**From:** Sarah Fletcher <fletchsa1@gmail.com>  
**Sent:** Thursday, March 16, 2023 6:56 PM  
**To:** Ryan Harriman  
**Cc:** Suzanne Skone; Dan Thompson; Mike or Susie Cero; Carv Zwingle; Thomas Acker; Council; Traci Granbois; Robert Medved; Jessi Bon  
**Subject:** Re: Public Comments SUB 19-002/Boys and Girls Club Long Subdivision

2/16/23
JOB NUMBER: 13-118
SHEET NAME: RS-01
SHT 6 OF 9

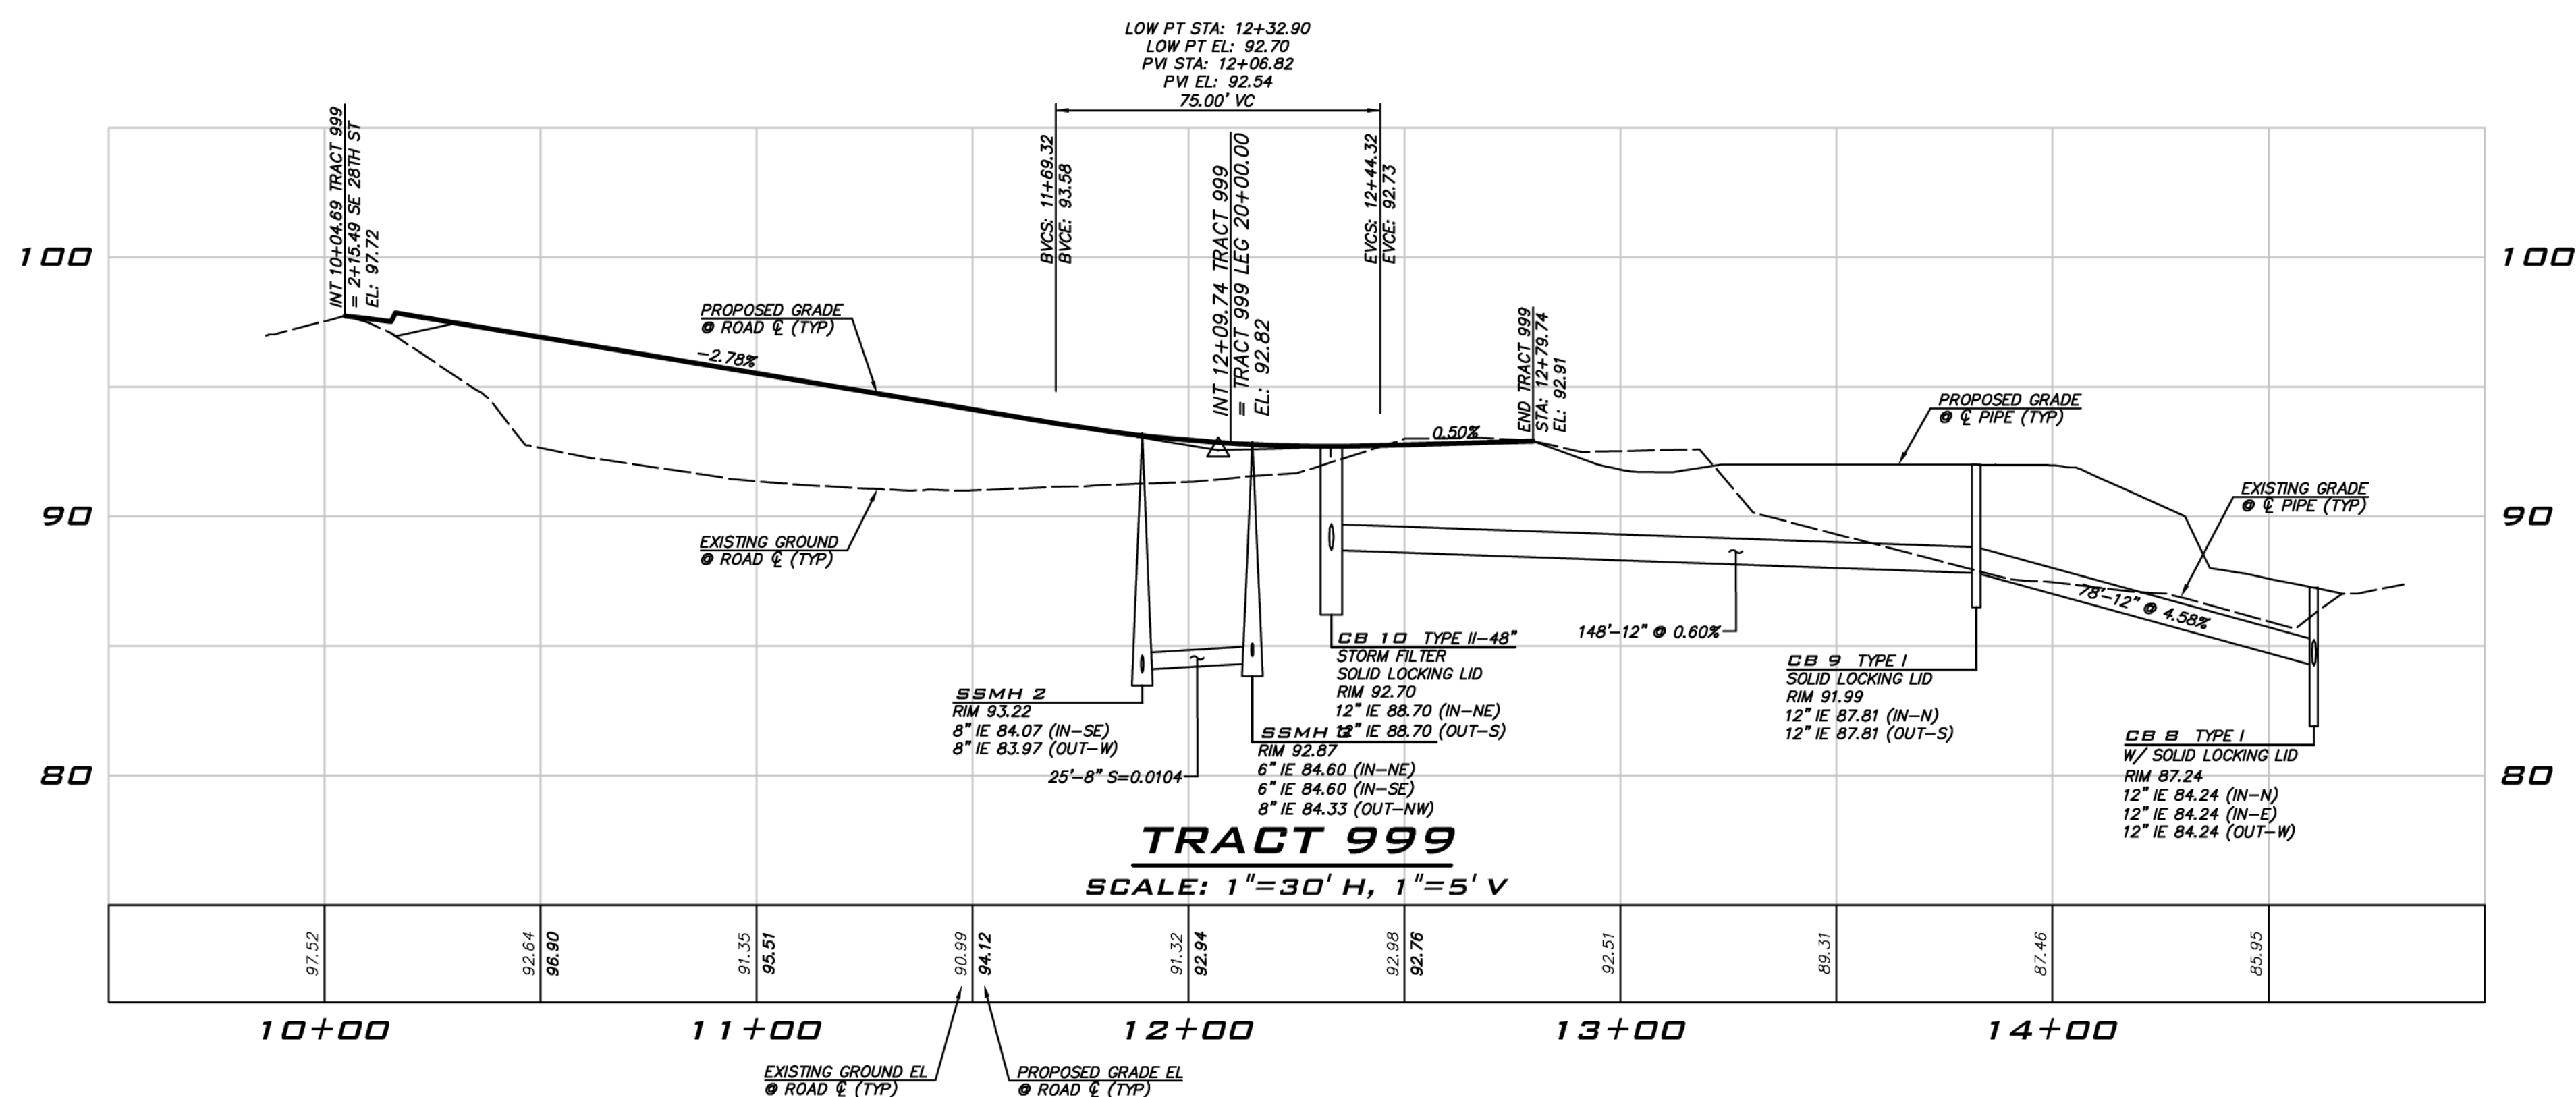
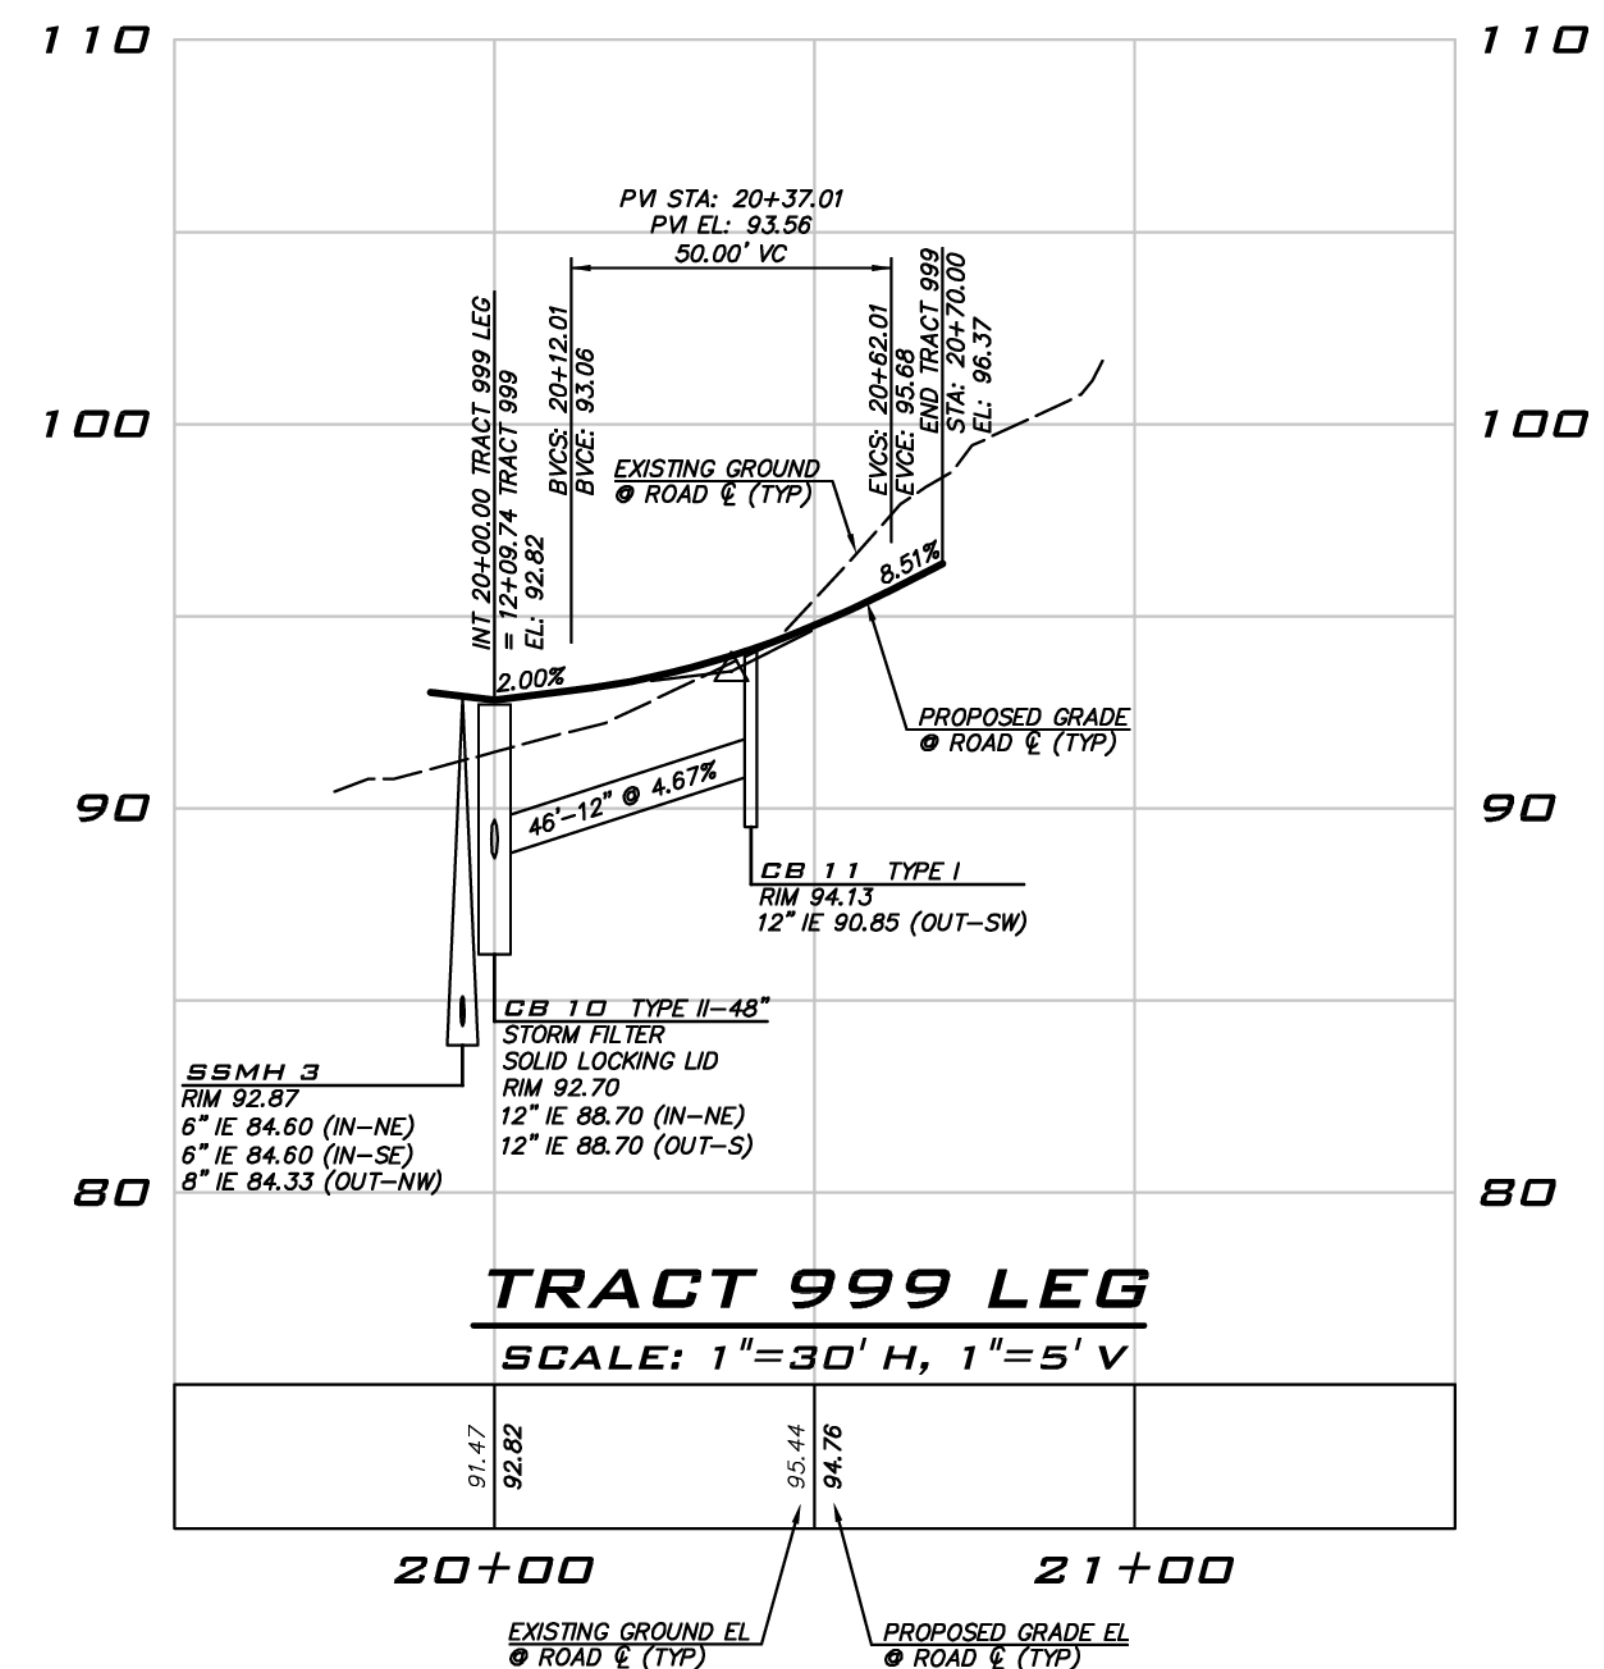
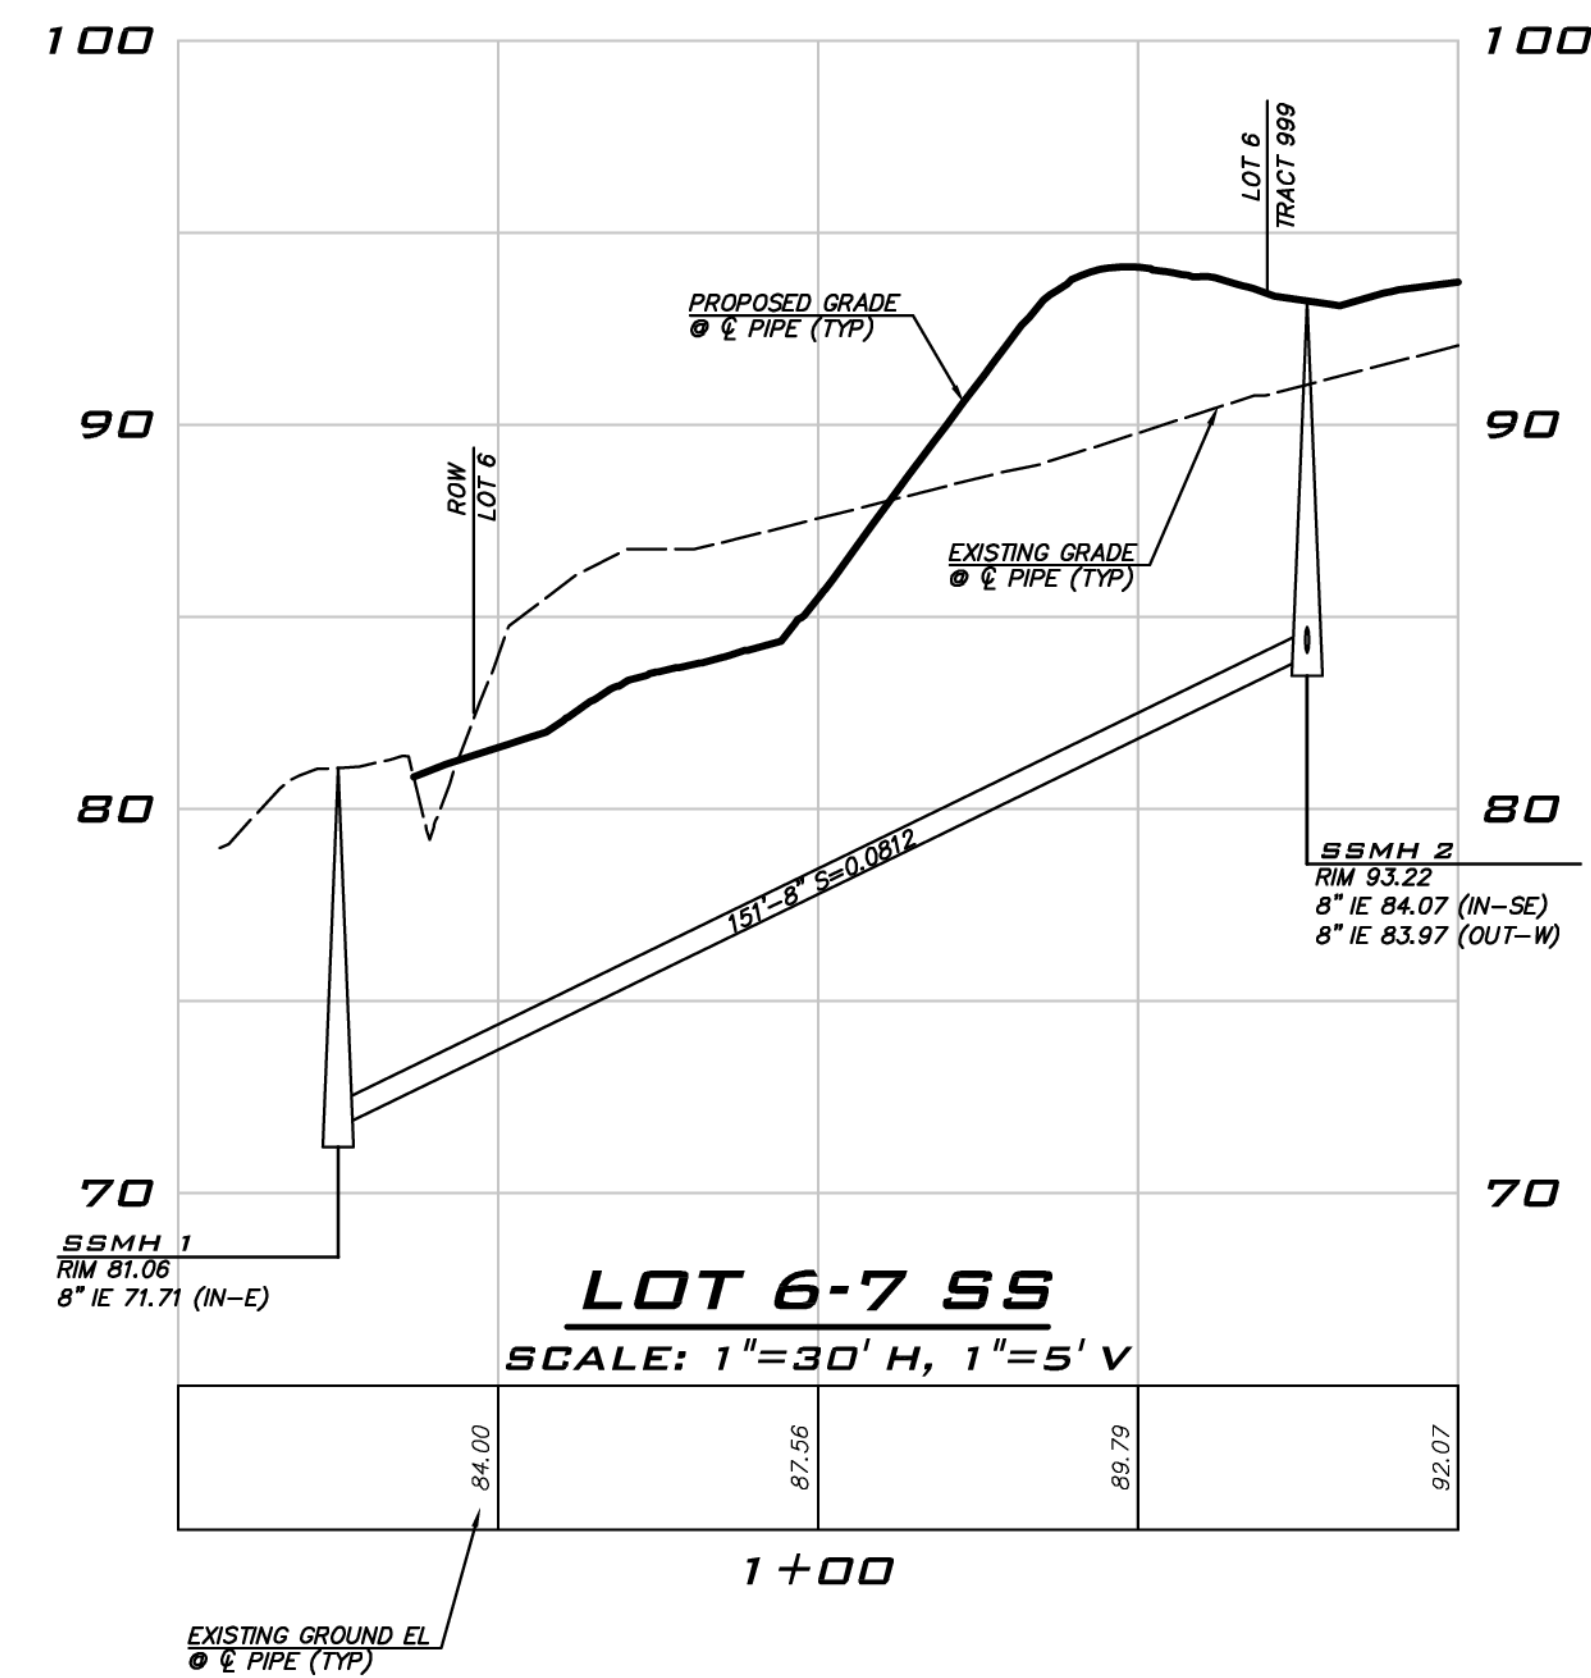
B. Ingress and egress should be by internal road for each house. The applicant no doubt does not like this since the internal road counts against lot area and lot coverage limits, but in my opinion the current plans are a danger to those walking or biking along adjacent streets. There is some internal access to some lots, but all access should be by an internal access road.
